Kirklees Metropolitan Council

Application Reference: 2025/91542

**Site: Erection of 40 dwellings and associated works, including formation of new
vehicular access and erection of cricket netting**

Sport England Reference: PA/25/Y/KK/71268

DRAWING TITLE
Proposed Site Layout

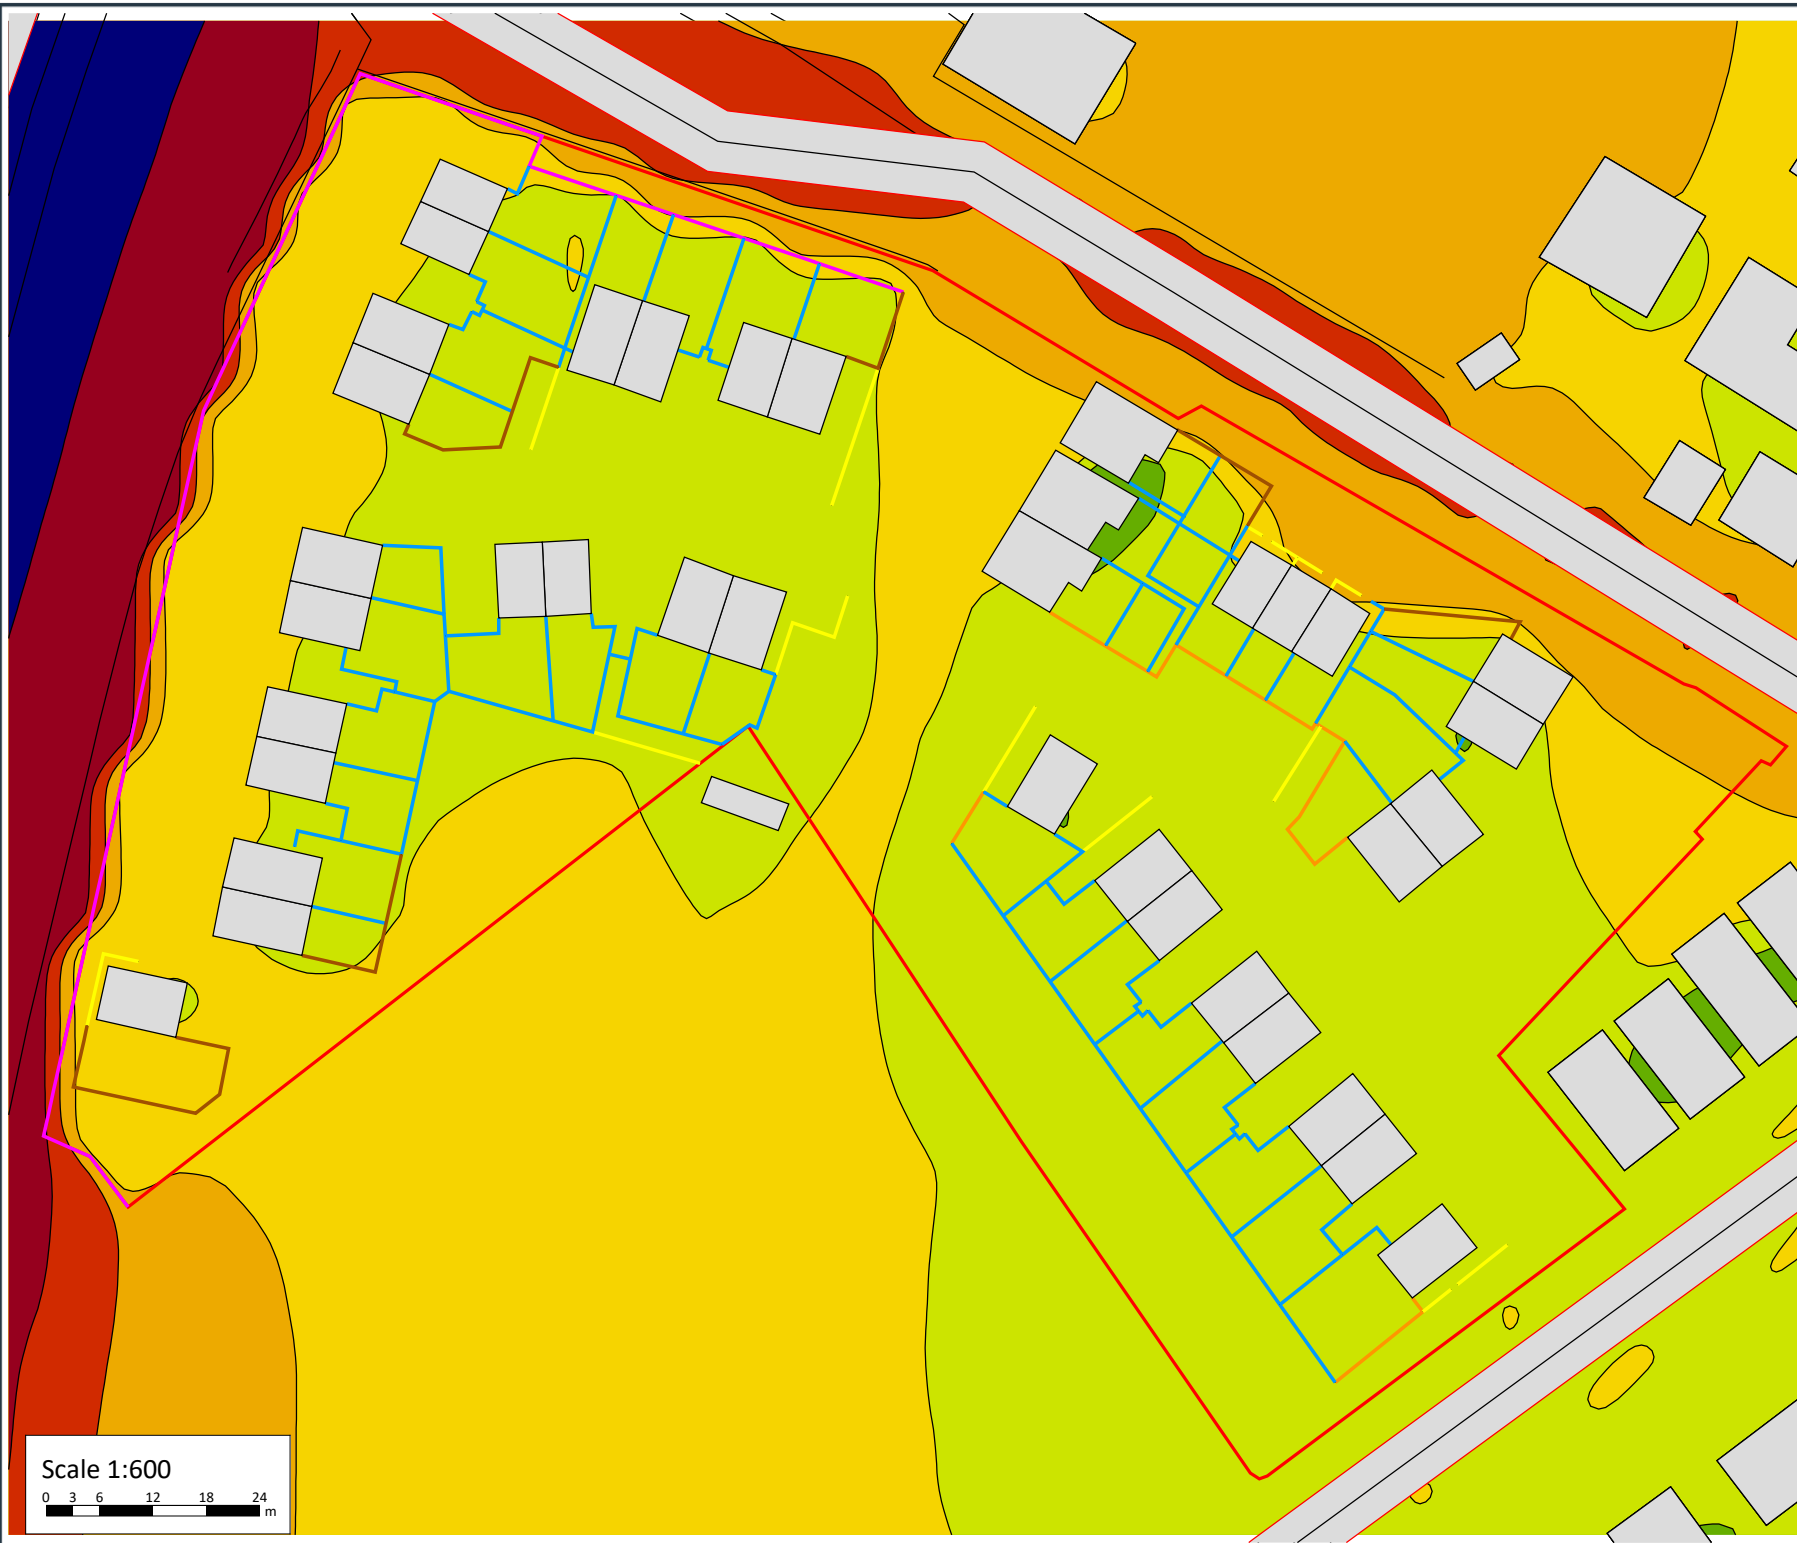
It is welcomed that the risk assessment has now considered the correct level of play and ball trajectory modelling for cricket. However, the following images appear to show that the proposed location of the mitigation would not cover the whole of the development site boundary with the cricket ground. As explained by the ECB, it is assumed that this may be due to the location of the existing trees between the cricket ground and the proposed housing development.

As such, Sport England concur with the ECB and request that the proposed mitigation is proposed across the whole development site boundary with the cricket ground.

Sport England note that the proposed location of the cricket netting is included on the proposed site plan. The proposed boundary treatment plan provides a illustrative drawing of the proposed netting and appears to refer to the Labosport Ball Assessment report. Also, the Design and Access Statement explains how “*the net to protect the units from ball strikes is located at the back of plot with a grasscrete access road for any maintenance requirements.*”

Sport England is aware from experience elsewhere that the location, design and height of mitigation measures in relation to houses has caused concerns for Local Planning Authorities from an amenity perspective. For this reason, Sport England advises that additional full and clear specification details and drawings of the proposed cricket netting should be provided as part of the current planning application in order for it to be considered acceptable to the Local Planning Authority.

1. A ball strike risk assessment, undertaken by a suitably qualified consultant, that examines the ball trajectory for cricket for the entire site boundary with the cricket ground.
2. If ball strike is identified as an issue, then clear and full details of the proposed design, specification and layout of any ball strike mitigation (for example ball stop fencing/netting) should be provided and for the entire site boundary. This should also include details of how any ball strike mitigation will be managed and maintained. Any ball strike mitigation provided should not have any encroachment onto the existing playing field/cricket ground and there should be no expectation that any
